Re: Status of Improvement Permit Application #06-5-15041R

Re: Status of Improvement Permit Application #06-5-15041R

Southeastern Properties
Lot D-9 Carolina Seawalls
06-50015041 R

PLOT PLAN 119 FOREST POND

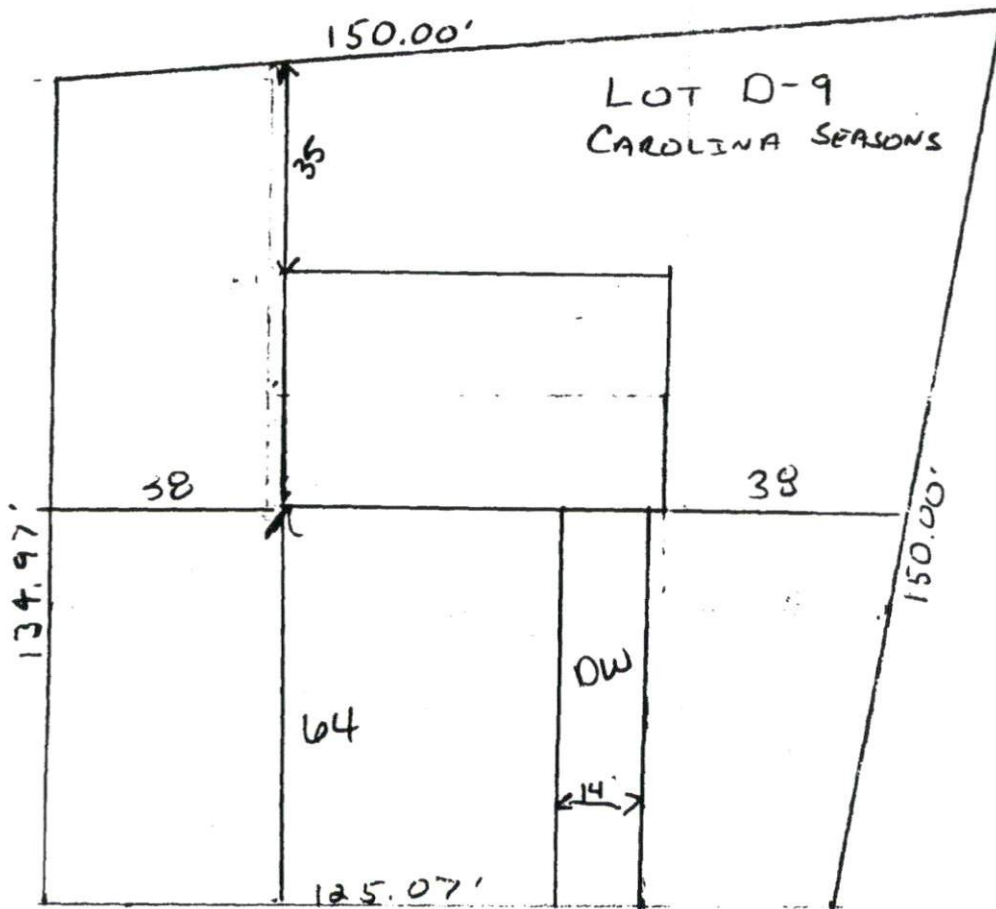
- 1) Surveyor must locate all property corners (true irons) and flag all property lines.
- 2) Clear underbrush from lot so that I may do septic system and repair layout.
- 3) You need to know that the house location, house size, (less than 4 bedrooms), may need to change to fit lot and soil conditions on lot. Septic system has to be 50' from high water mark of the pond. Septic system may require the use of pump, and an alternative type system.
- 4) If you have questions about what I need to have done please call me at 910-893-7547

PLOT PLAN 119 FOREST POND

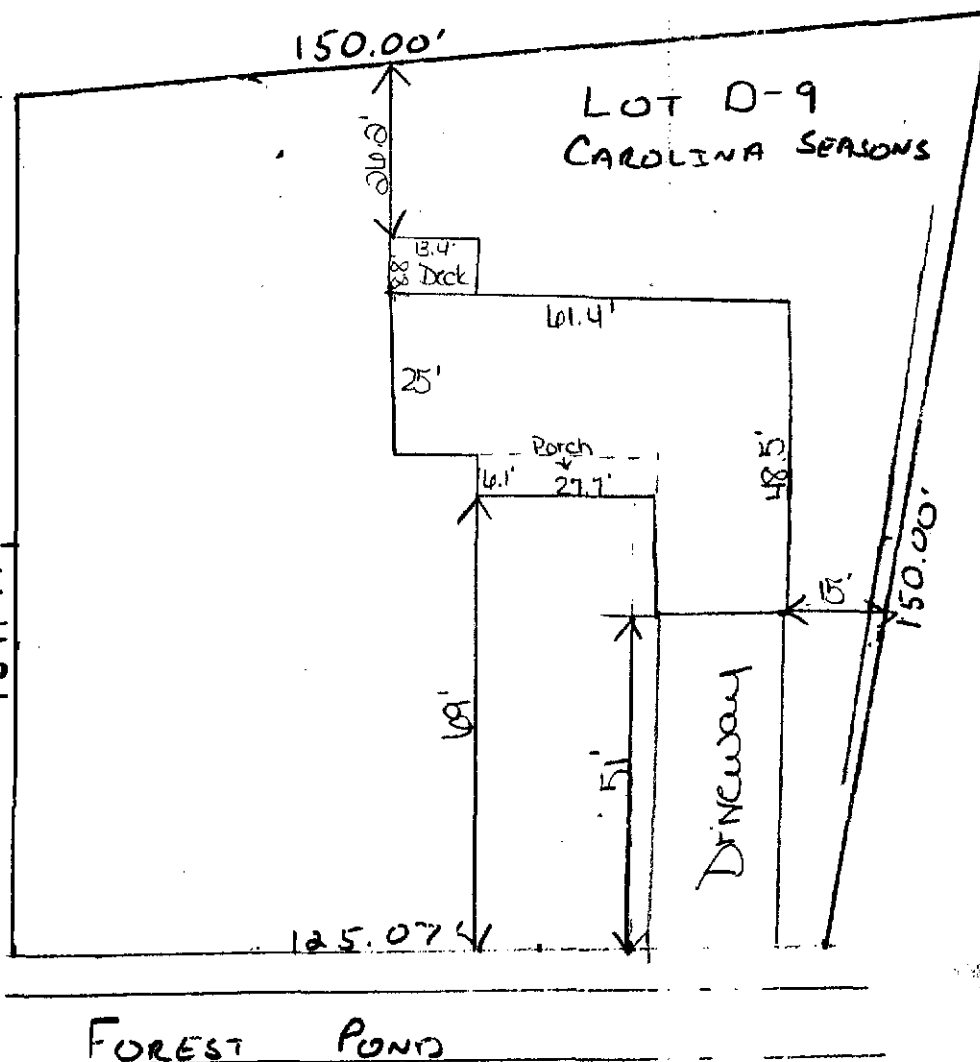
- _____ 1. Property lines/corners not marked or labeled
- _____ 2. House corners not marked or labeled
- _____ 3. Directions not clear to property
- _____ 4. Property needs brush or vegetation removed
- _____ 5. Backhoe pits required
- _____ 6. Other – You will need to move house as shown on the attached sheet and reduce the size of the house to 30 x 55 and the number of bedrooms to 3. Please submit new plot plan to Central Permitting so that I can issue a permit for you.
